## ADDENDUM 02

Date: February 28, 2017

Regarding: **191 Marginal Way Retail Center** – Portland, Maine

**Modify the previously issued Building “Contract Documents,” dated February 10, 2017 and any previously issued addenda, if applicable, as follows:**

DRAWING NUMBER  
**E1.00**

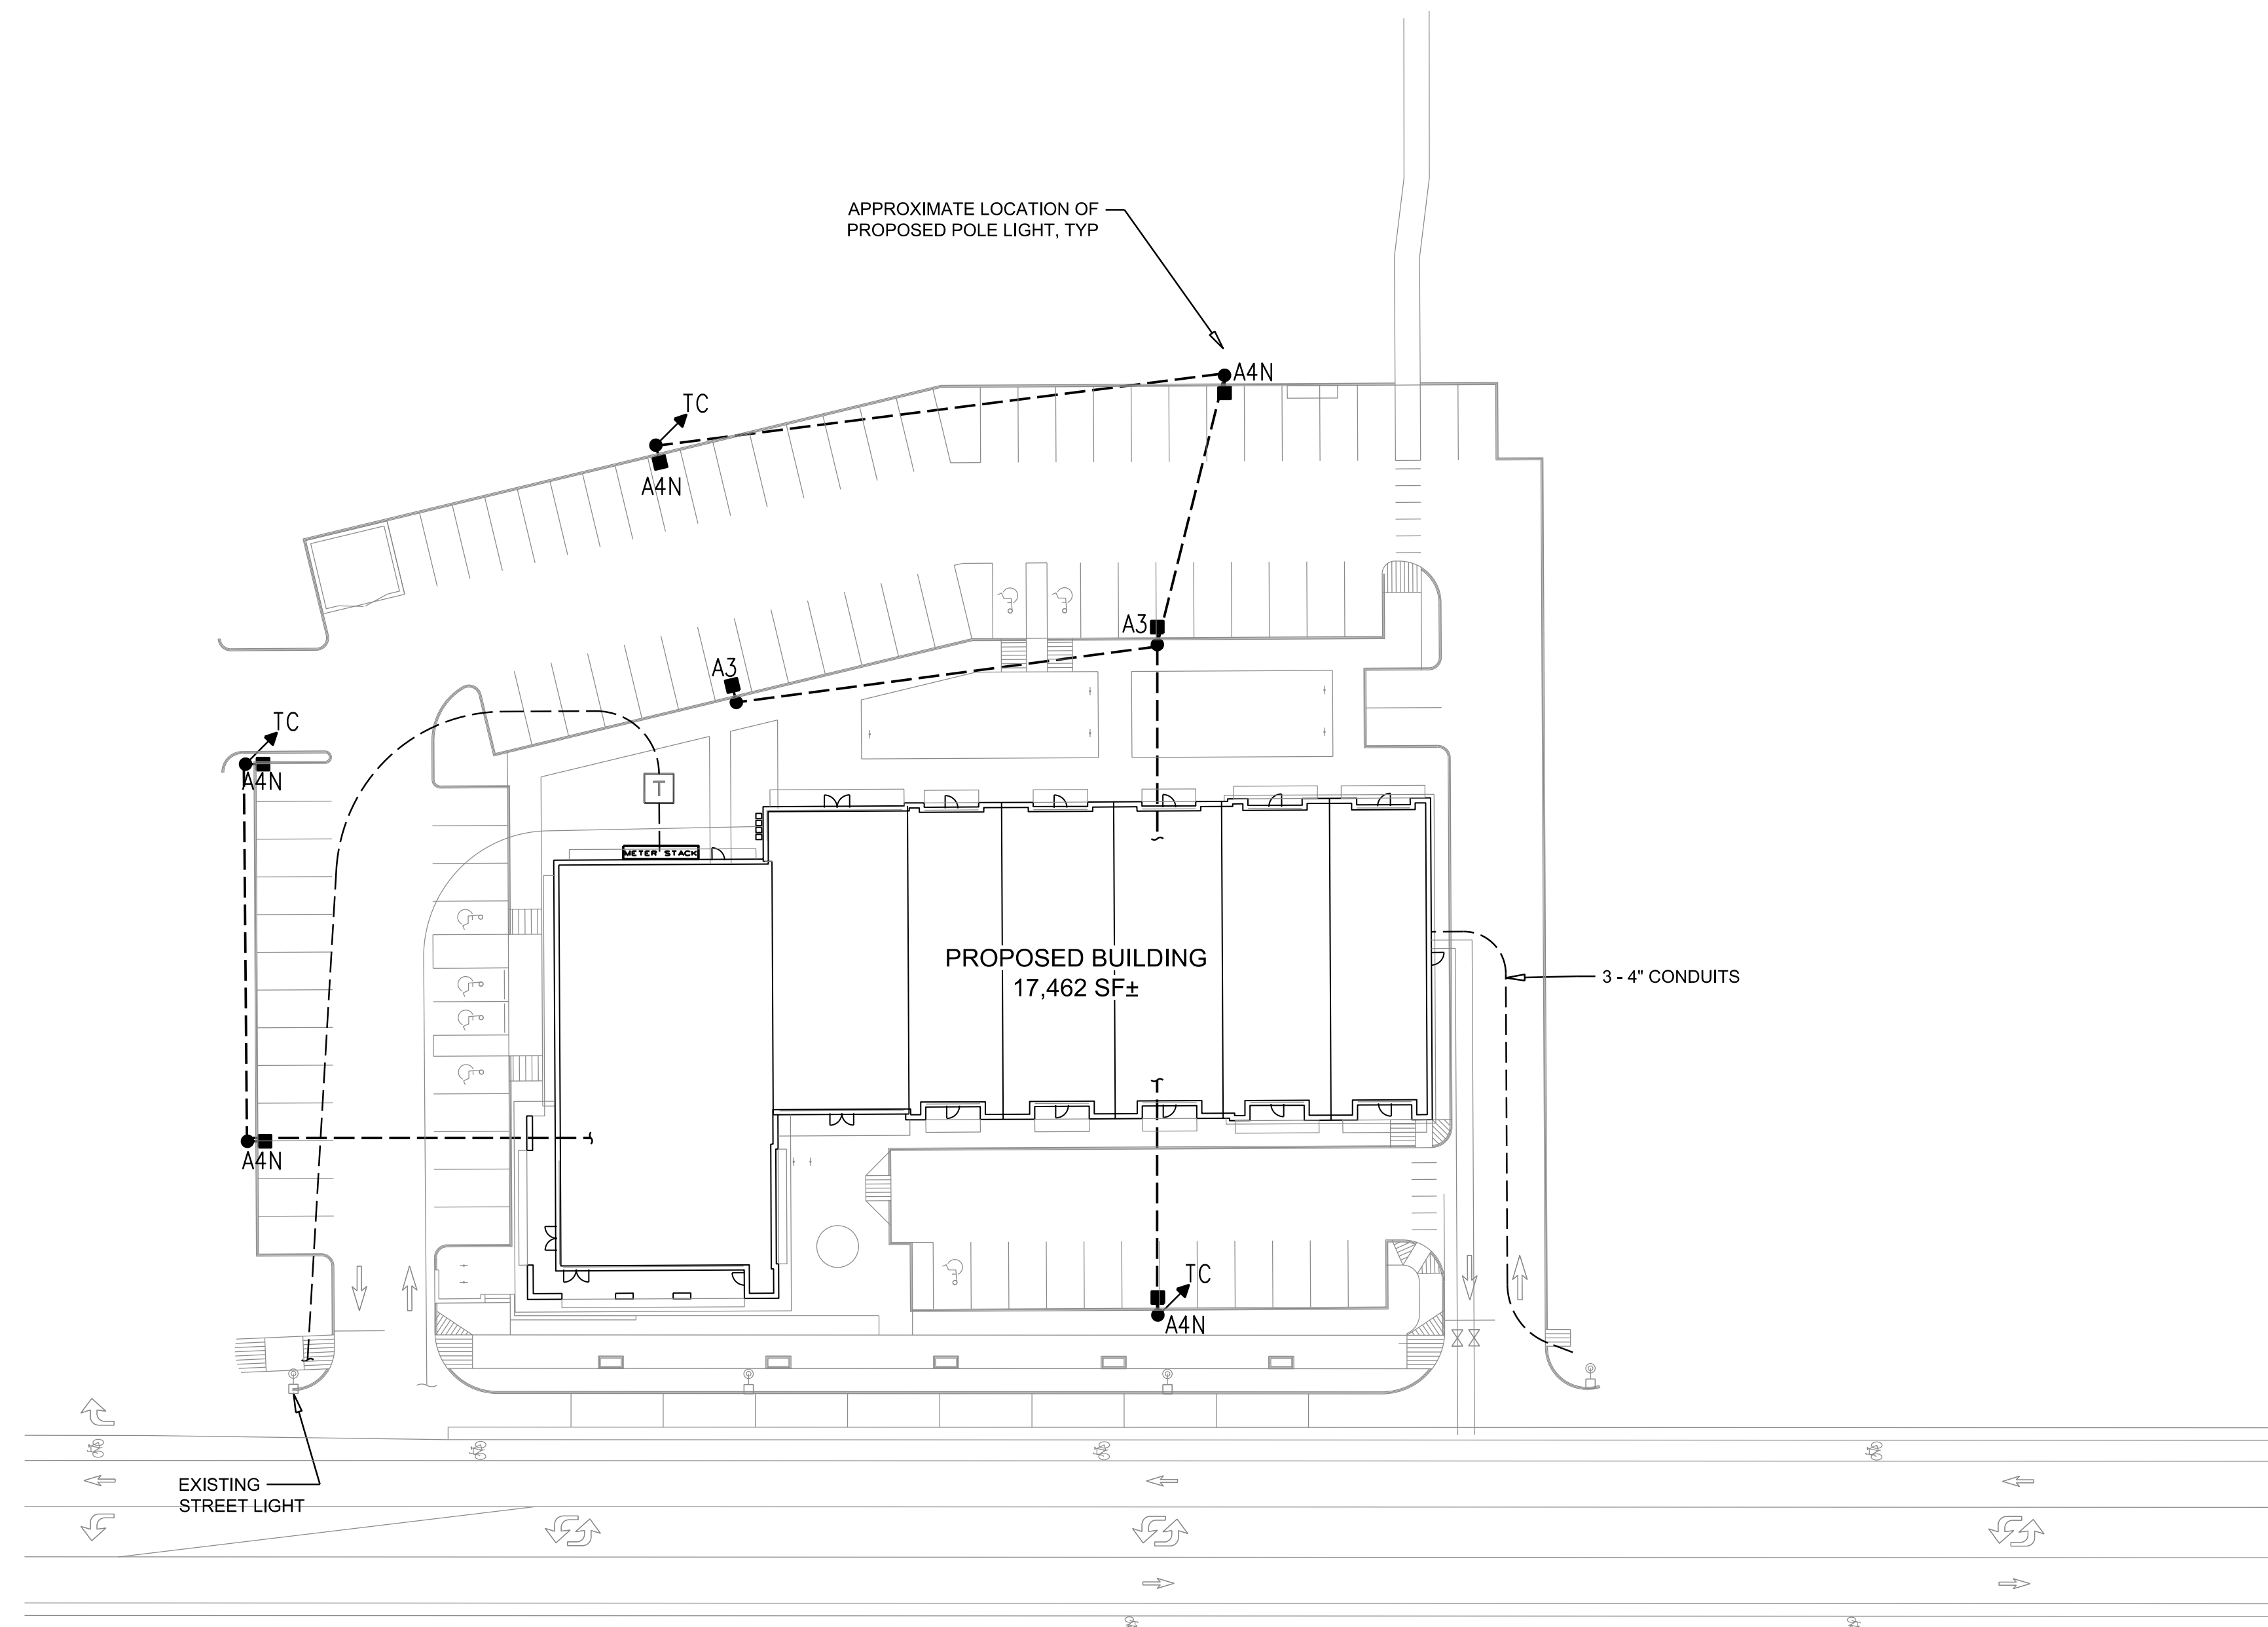
8. QUESTION: C5 drawing indicates 8 parking lot fixtures and 4 “Bayside” Holophane fixtures but E1.00 shows 7 parking lot fixtures and no poles on Marginal Way. Please advise.  
ANSWER: Default to the Civil plans for numbers for parking lot fixtures.

DRAWING
**ELECTRICAL LEGEND,
NOTES AND ONE-LINE
DIAGRAM**

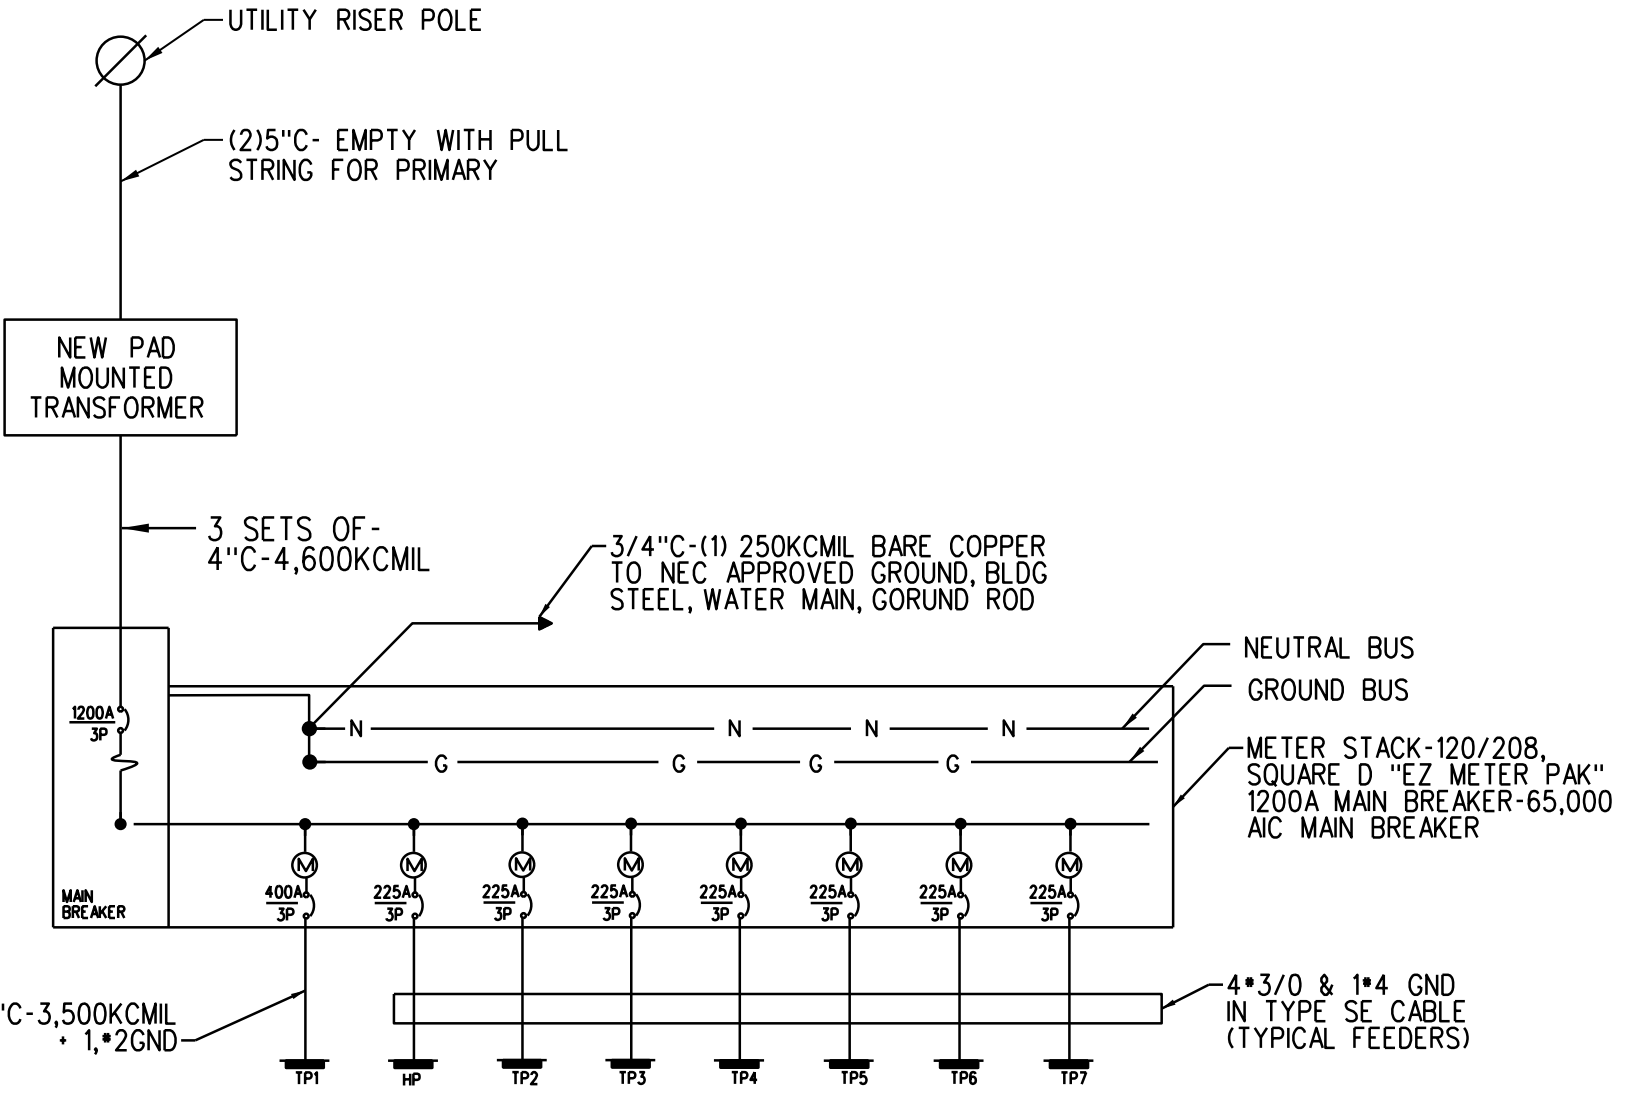
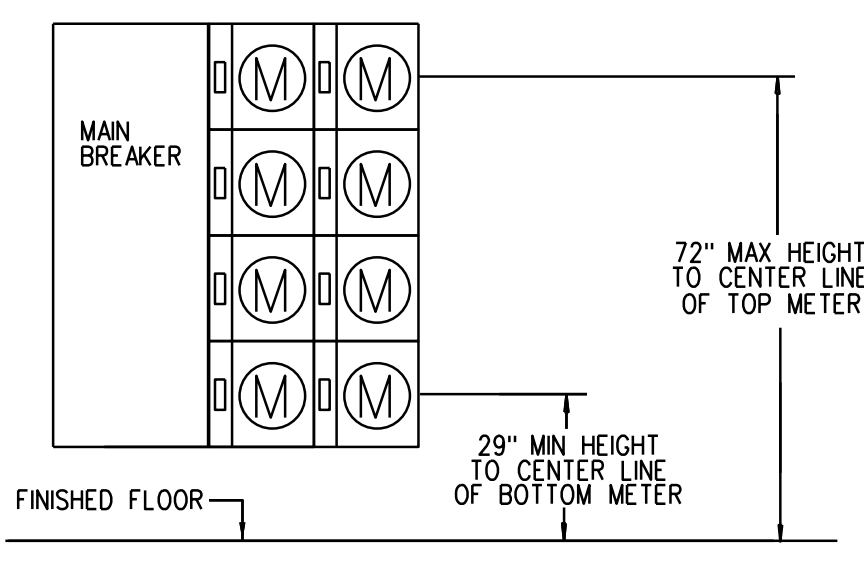
9. **Sheet E2.00:** Revise One-line Diagram to show (4) 500KCMIL + (1)#2 GND wire all within a 3” conduit to TP1.
